Subject: FW: LU/134/21/PL & LU/135/21/L The Farm, East Street, Littlehampton - CONSERVATION OFFICER COMMENTS FIREPLACE

Pls add below email to case files x 2 as above and label as 'Conservation Officer comments – re fireplace/chimney breast proposals'

Subject: RE: LU/134/21/PL & LU/135/21/L The Farm, East Street, Littlehampton

Drawing Name
Cellar, Ground Floor and First Floor Plans - Proposed

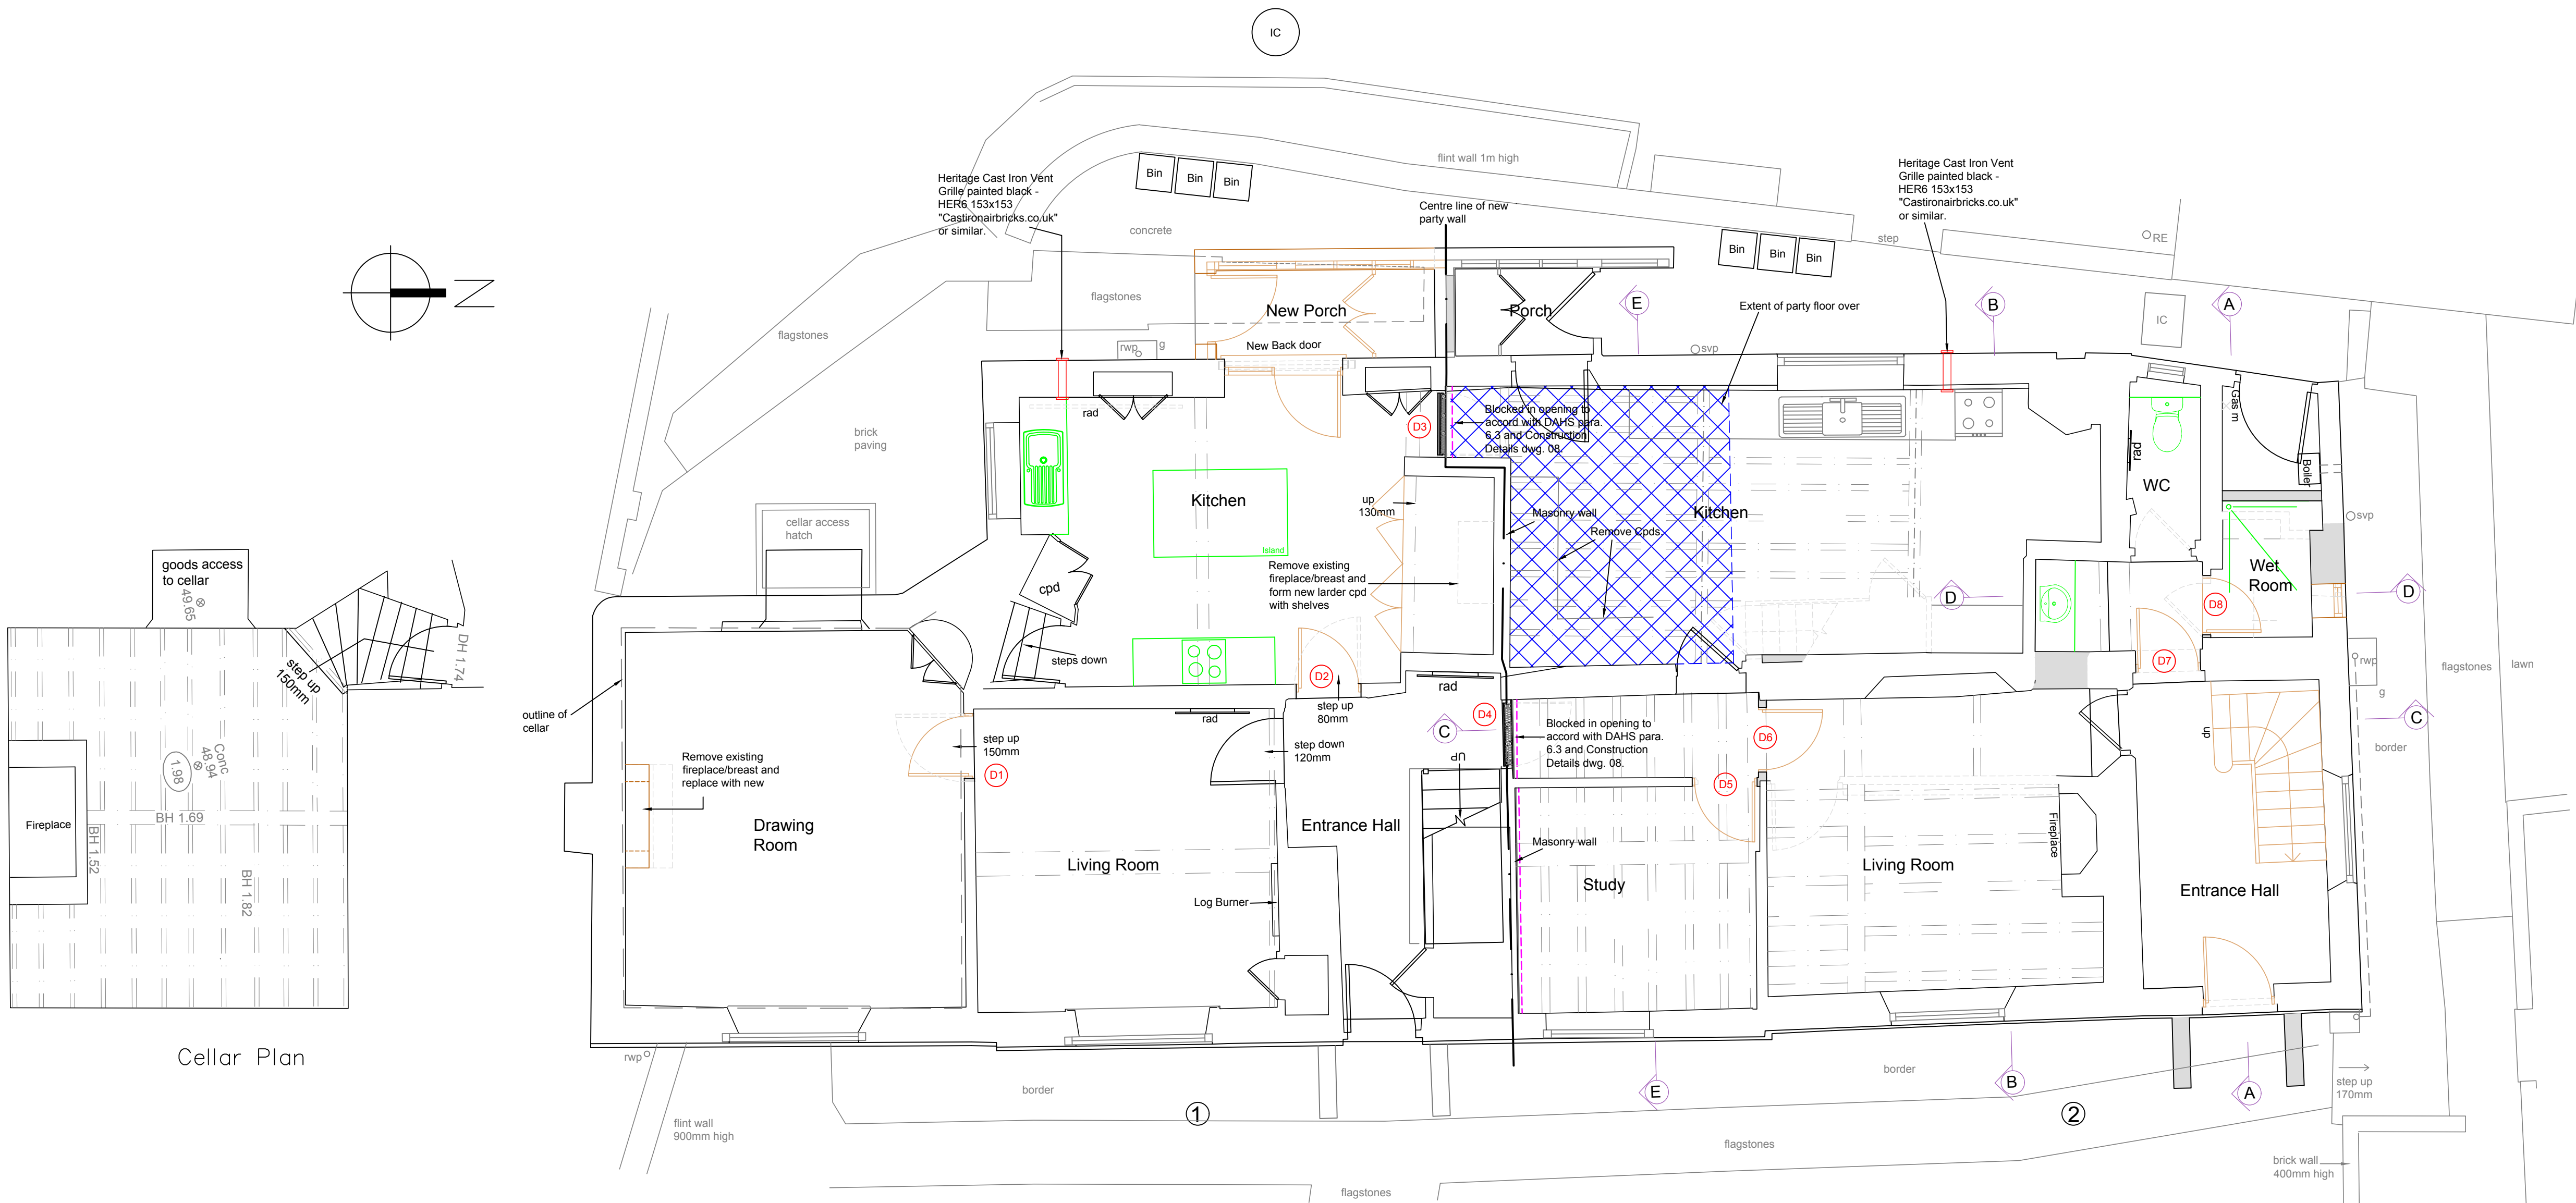
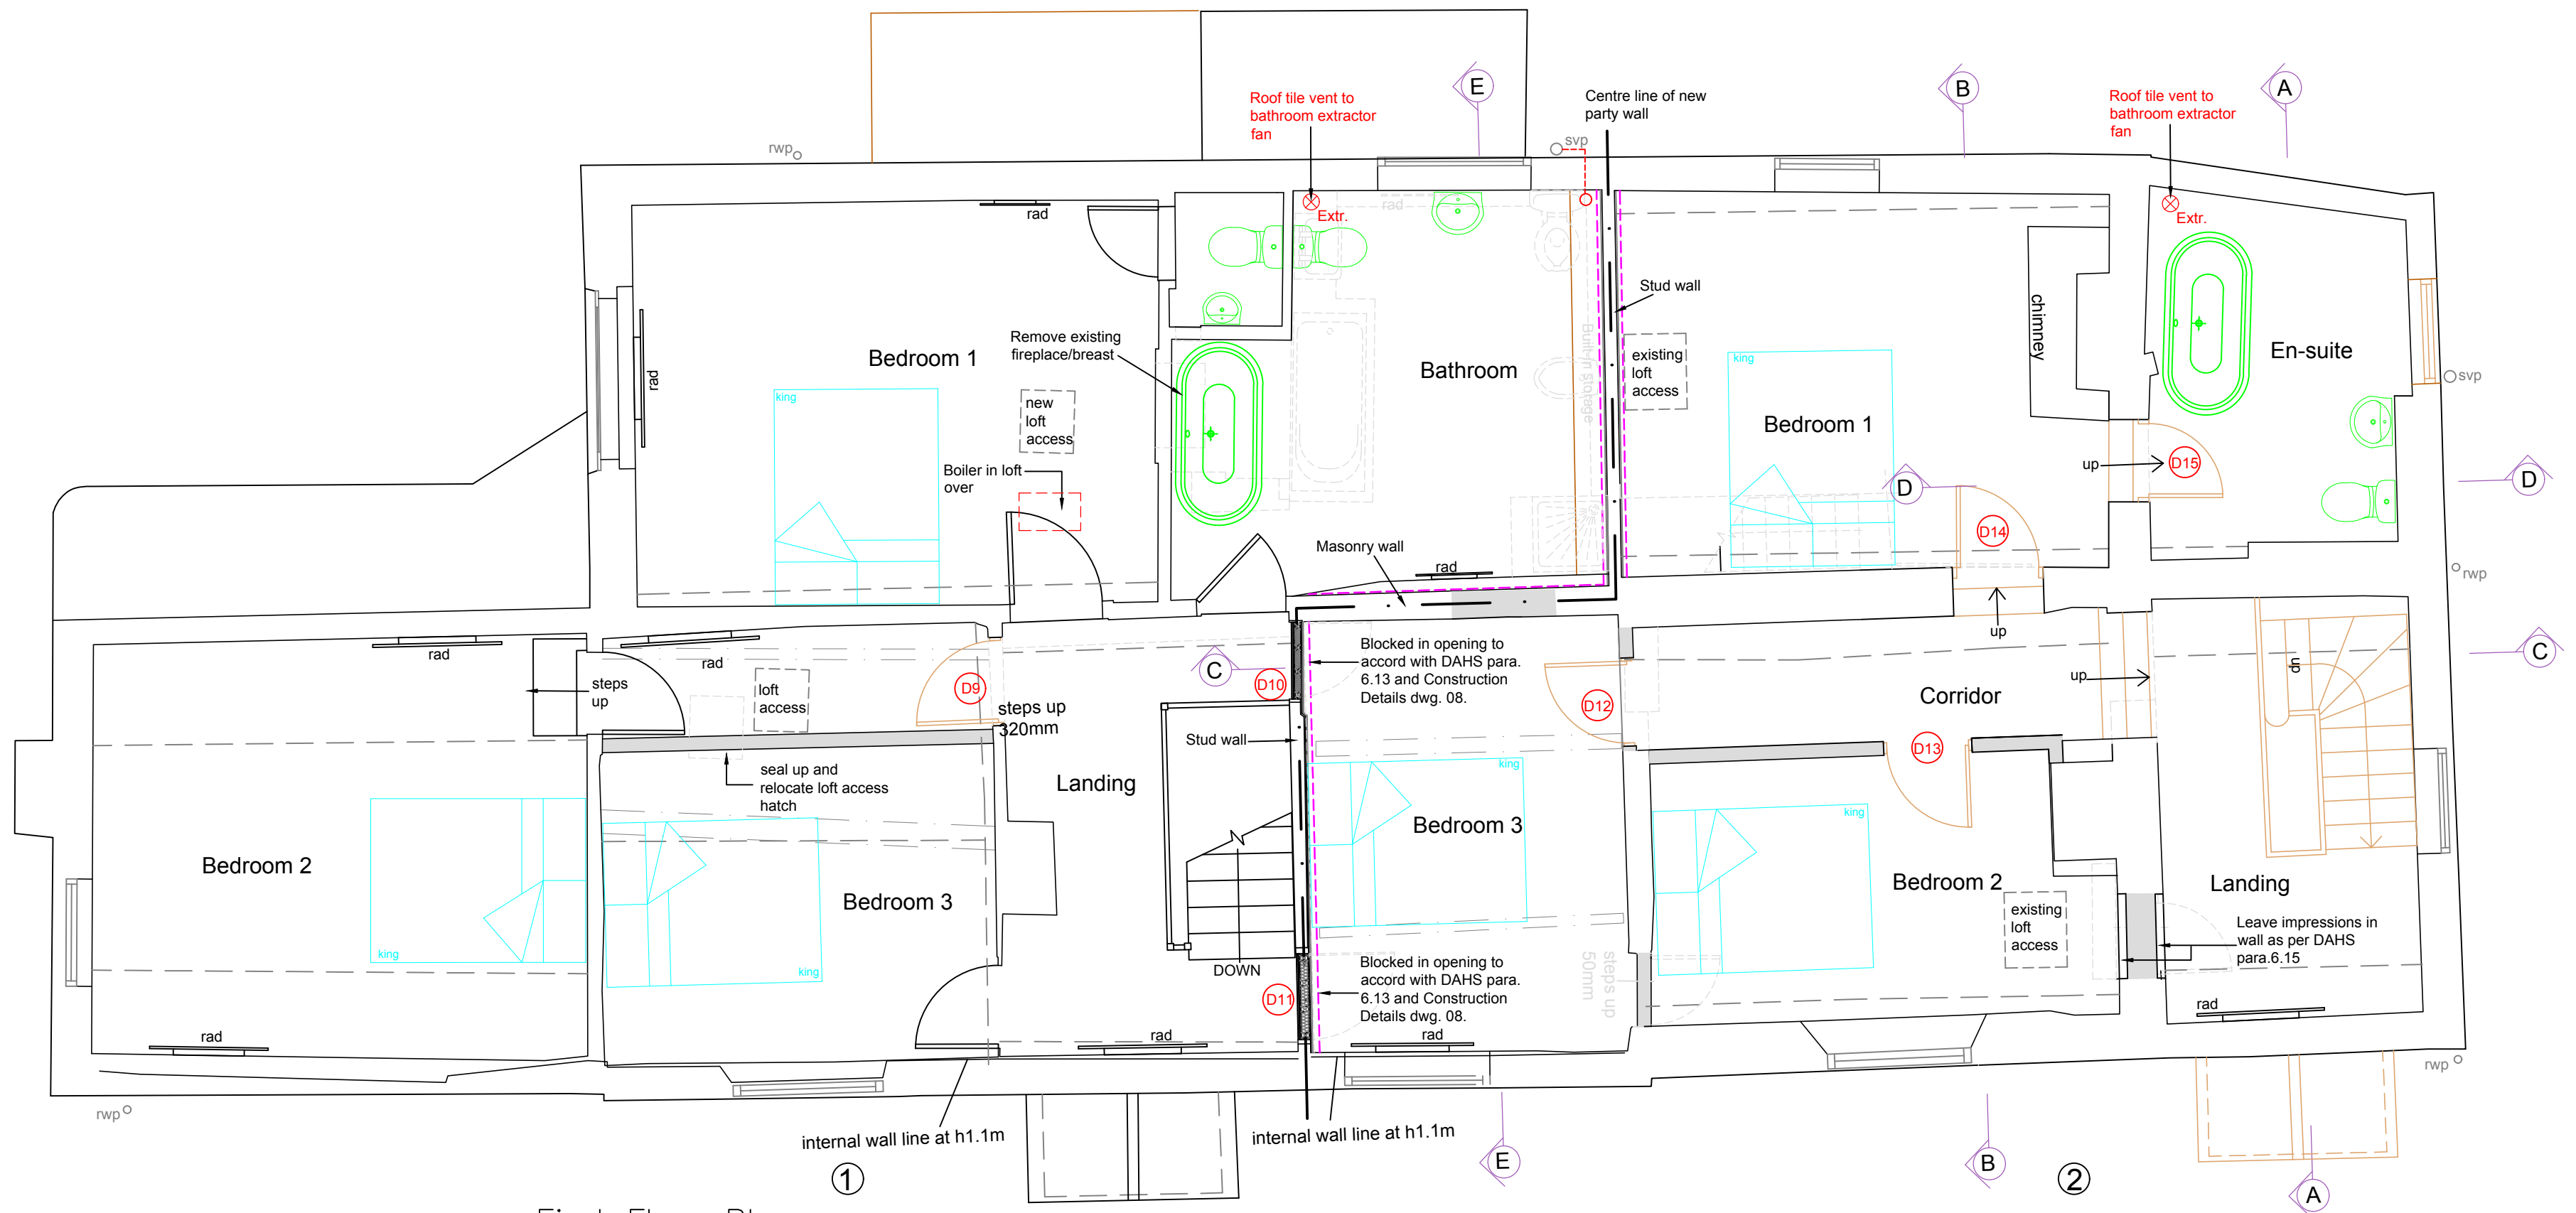
Why is there loss of the fireplace/chimney breast at the first floor level in the existing bathroom. It is not clear why this has to be removed, and ideally it would be retained?

In respect to your concern over the loss of the fireplace / chimney breast in the bathroom, I have discussed this with our clients, and confirm they are happy that it is retained. The existing fireplace is a later addition(please see attached image). The proposal is now to simply remove this more recently added fireplace at ground floor to bring it back to the original form, as shown in a picture in the attached document, and the larder to be built around it and retain the structure above.

We are confident that this would be acceptable to the Conservation Officer from past consultation as there would be no loss of the original building fabric.
